Report following a request for further information, negotiations or consultation

REF NO: FG/135/19/PL

LOCATION: Silo at Former McIntyre Nursery
Littlehampton Road
Ferring

PROPOSAL: Demolition of a silo & erection of an office building (B1(a) Business), 6 No. parking spaces for office workers & erection of boundary fencing.

SCALE AT A1: As indicated	DATE: 14/05/19	DRAWN: AP	CHECKED:
PROJECT NO: SILO	DRAWING NO: WLD/0063/19/02	REVISION:	C

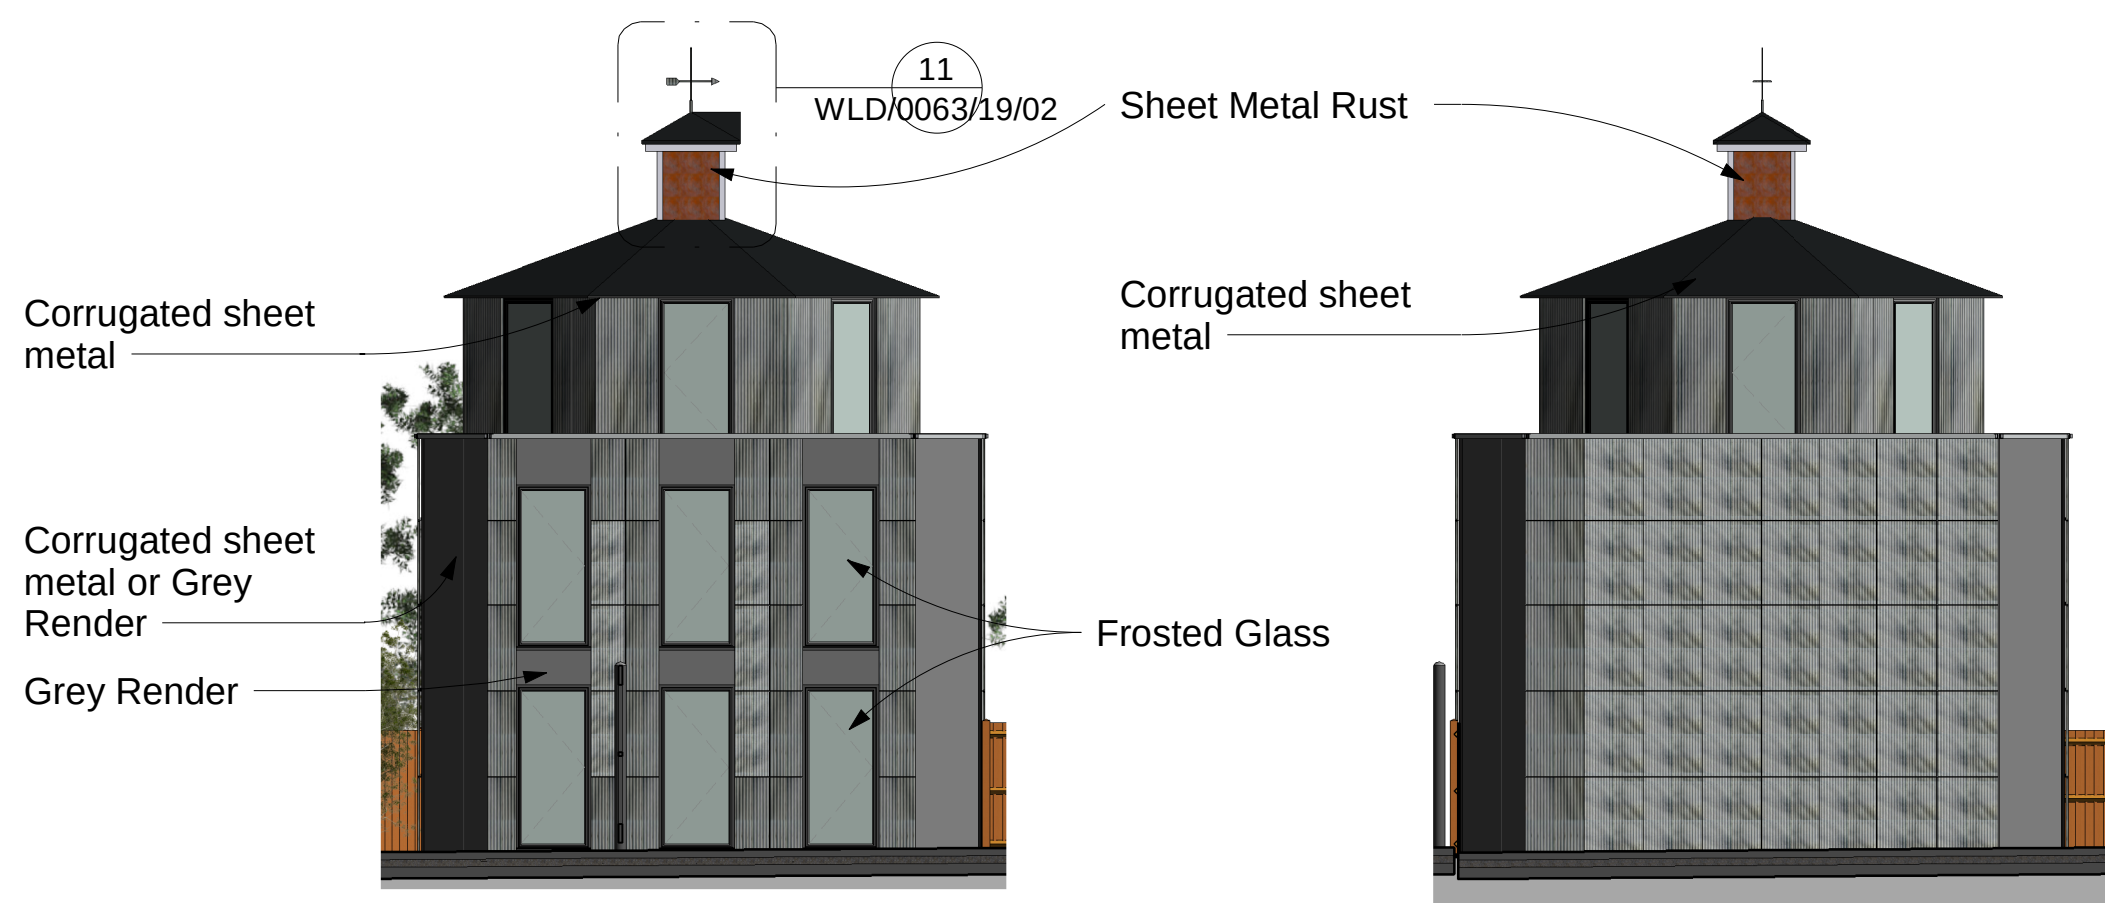
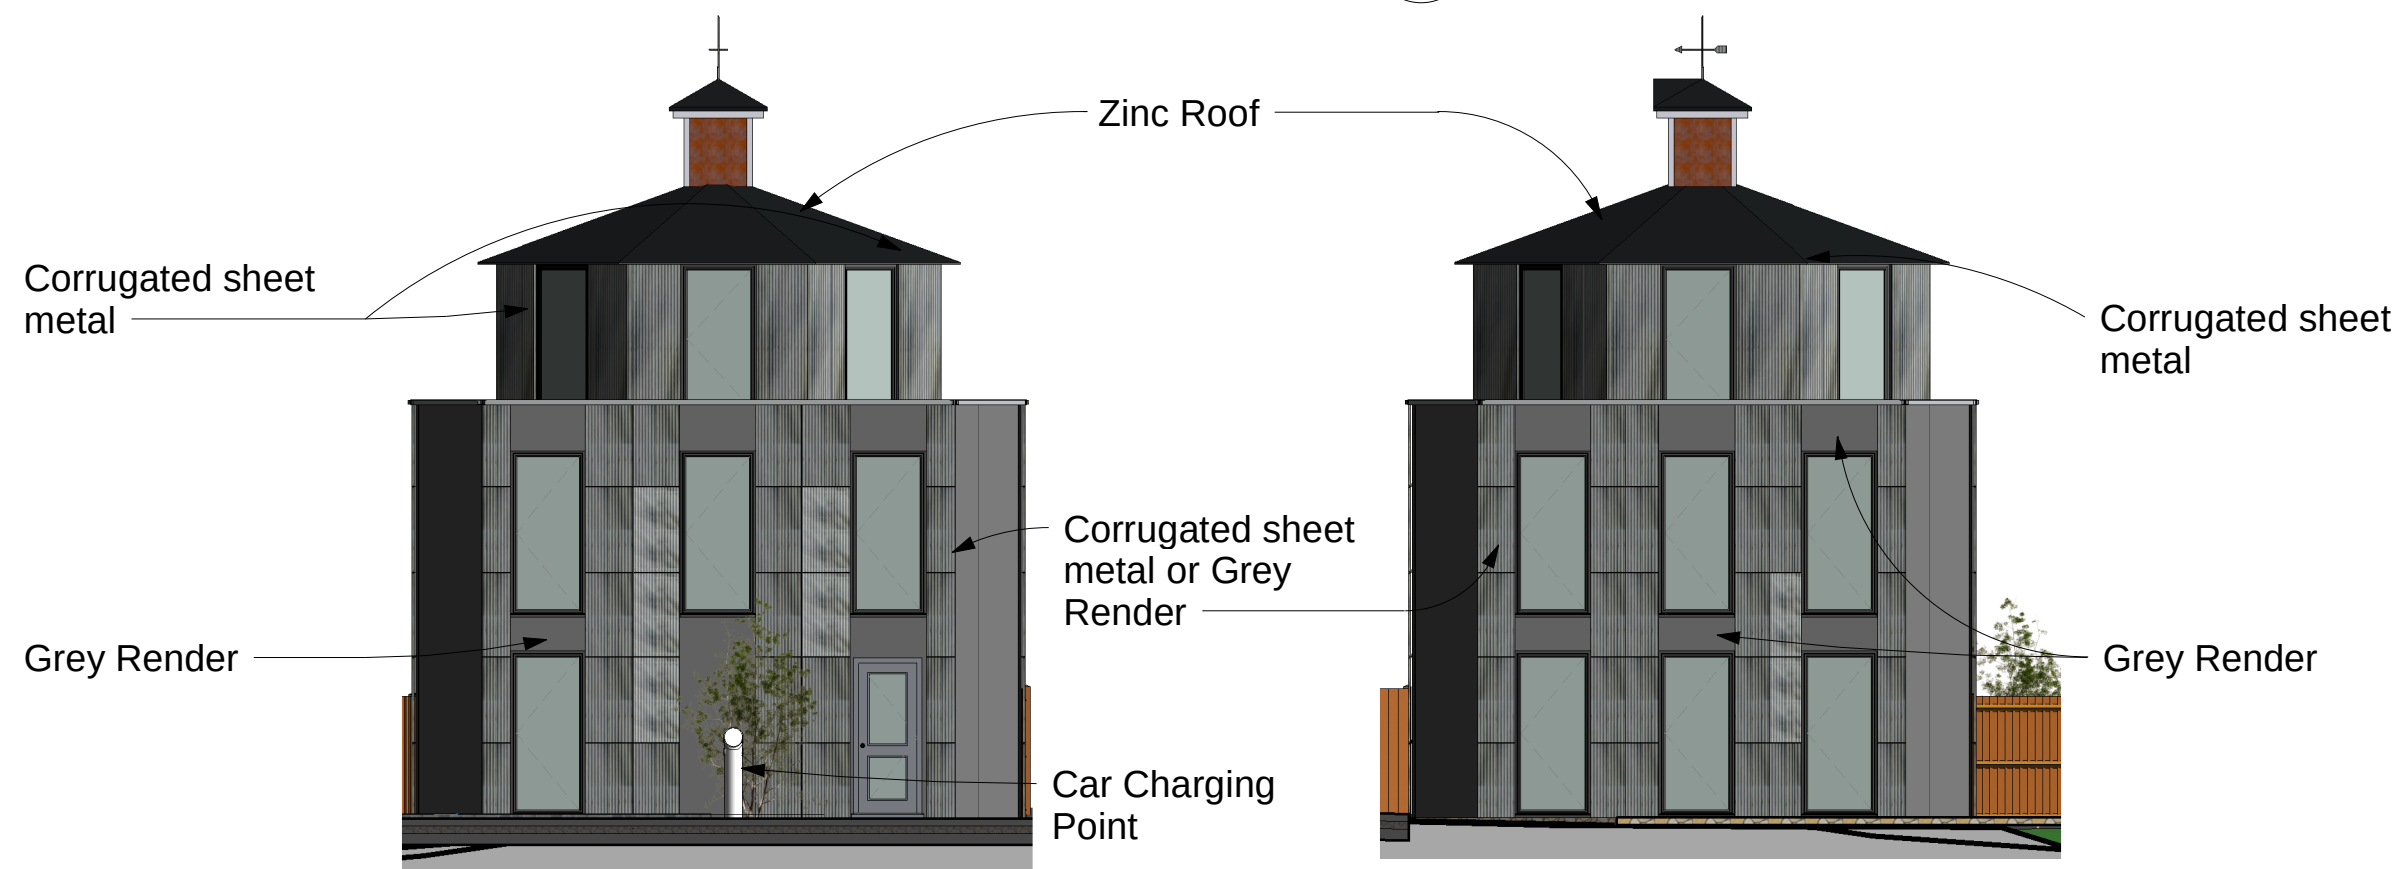
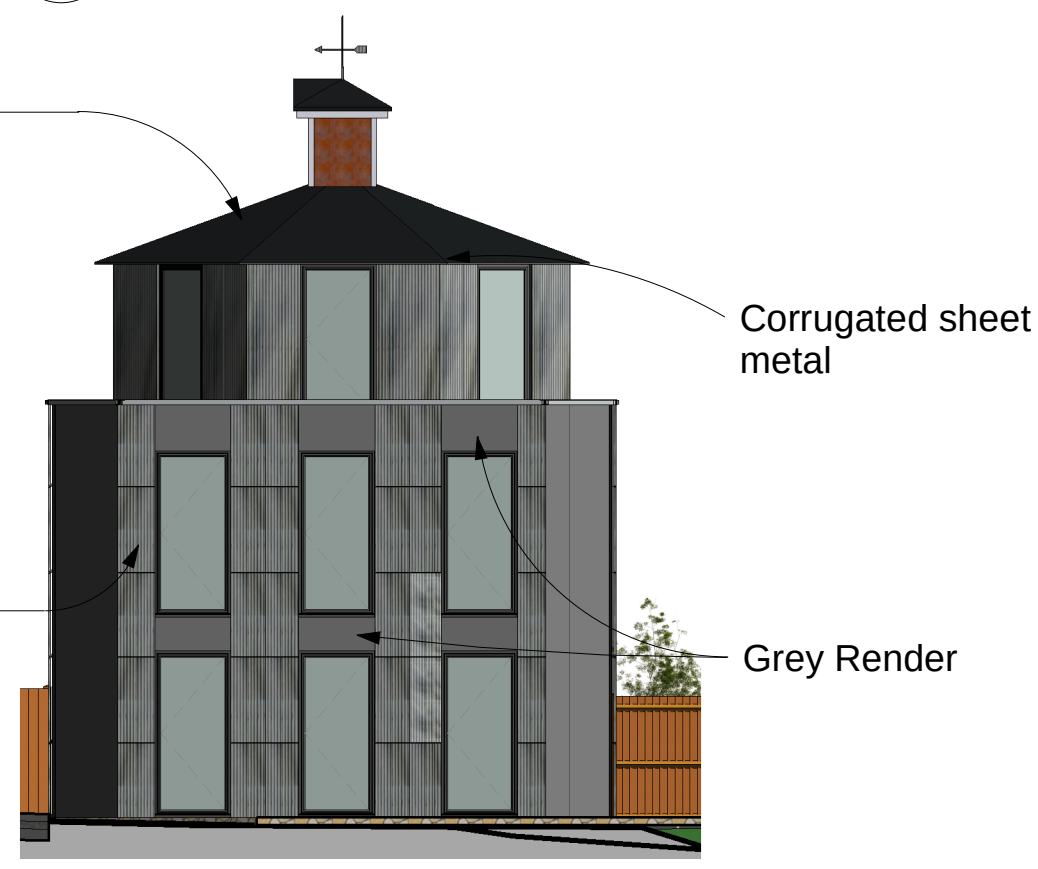
Previously, the proposal utilised corrugated sheet metal and grey render for its walls. These materials were considered to be inappropriate and alternative options have been put forward using natural timber cladding and white render which are considered to be more sympathetic materials in this semi-rural setting. The proposed designs involve the loss of the weathervane which was also considered by some members to be an alien feature.

Officers have assessed a number of submitted schemes and consider the use of cladding between the windows and cladding of the elevations of the octagonal second floor as the most appropriate.

In order to ensure that the proposed materials create a visually acceptable development, full details of the proposed materials will be ensured via amending the plans condition number 2 as per the attached report.
